A19 Downhill Lane Junction Improvement
Scheme Number: TR010024
7.22 Applicant's Responses to ExA's Second
Written Questions (ExQ2)

APPLICANT'S RESPONSES TO EXA'S SECOND WRITTEN QUESTIONS (EXQ2)

Regulation Number:	Rule 8(1)(b)
Planning Inspectorate Scheme Reference	TR010024
Application Document Reference	TR010024/APP/7.22
Author:	A19 Project Team, Highways England Project Team & Jacobs

Drawing title: **STREETS, RIGHTS OF WAY AND ACCESS PLANS REGULATION 5(2)(k) SHEET 1 OF 2**

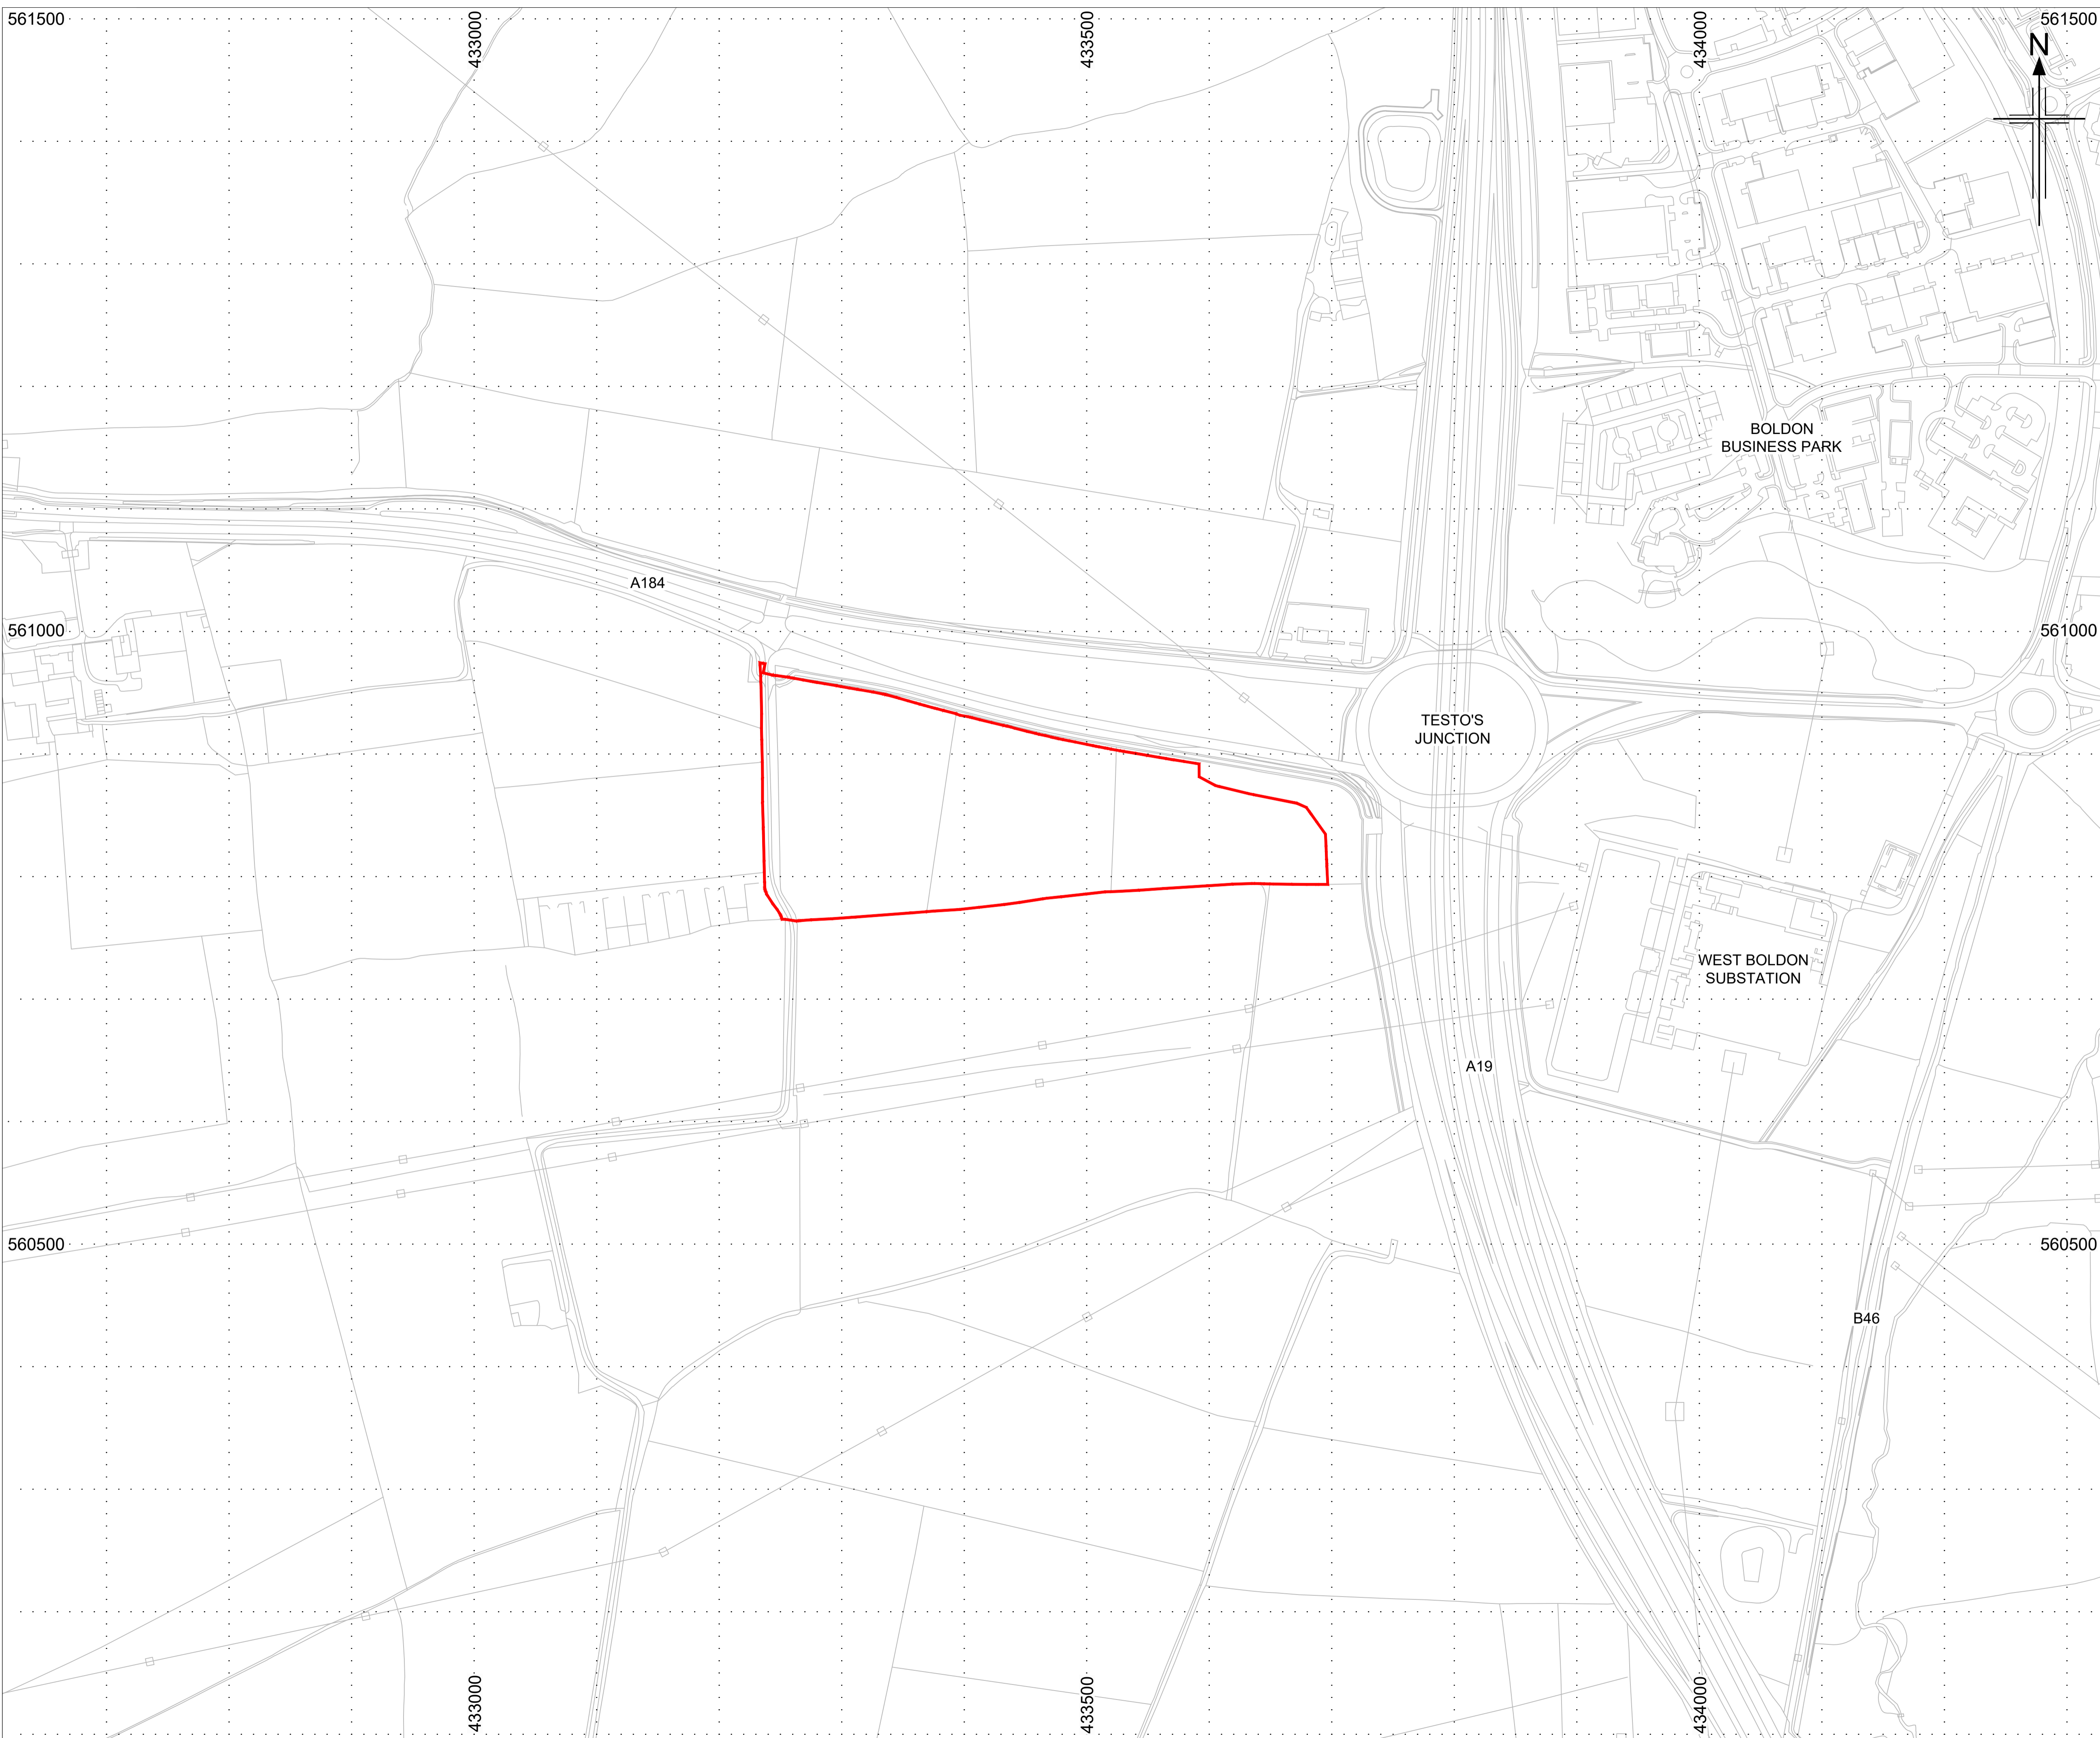
Q2.5.5	Applicant	<p>The ExA has proposed an amendment to Art 36(1) to ensure that the proposed changes to the Testo's scheme are only implemented provided that work on the original Testo's NMU scheme has not commenced. This is intended to ensure that the A19 Downhill Lane Junction Scheme's proposals for NMU users would not be prevented from implementation and would remove the uncertainty which could arise in the unlikely event that Works 4 and 6 of the Testo's scheme had commenced.</p> <p>The Applicant is asked to comment on the proposed amendment to Art 36(1) and specifically whether it would affect the flexibility which the Applicant seeks to have in implementing the Testo's scheme alongside the Downhill Lane Junction</p>	<p>By way of a preliminary comment, the Applicant would note that:</p> <ul style="list-style-type: none"> - the principal reason for the inclusion of article 36 is the removal of a NMU facility authorised by the Testo's project, which potentially promotes an unsafe NMU movement as a result of the A19 Downhill Lane project (the DLJ Scheme) proposals; - if the DLJ Scheme is authorised and constructed, this NMU facility (if not removed from the Testo's Order) would effectively lead to a dead end;

In light of the ExA's question and related drafting proposal on Article 36(1), and in light of recent developments on the Testo's scheme, the Applicant is now proposing:

- amendments to Schedule 8 to the dDCO to address the effects on Work No. 6 of the Testo's Order; and
- amendments to Article 36(1) and Schedule 8 to address the effects on Work No. 4 in the Testo's Order.

<table><tr> <th data-bbox="1317 922 1727 954">Document</th> <th data-bbox="1727 922 2136 954">Change</th> </tr><tr> <td data-bbox="1317 1257 1727 1436">Streets, Rights of Way and Access Plans (TR010024/APP/2.5(1))</td> <td data-bbox="1727 1257 2136 1436">Removal of the part of the B46 which was previously proposed to be reinstated. This is now shown as extinguished under the Testo's Order (as originally anticipated under that Order).</td> </tr></table>

<table><tr> <td data-bbox="1312 201 1727 379"></td> <td data-bbox="1727 201 2139 379"> Insertion of the extinguishment of the additional part of the B46 (Part 1/P to 1/Q) which will be extinguished on commencement of the DLJ Scheme. </td> </tr></table>
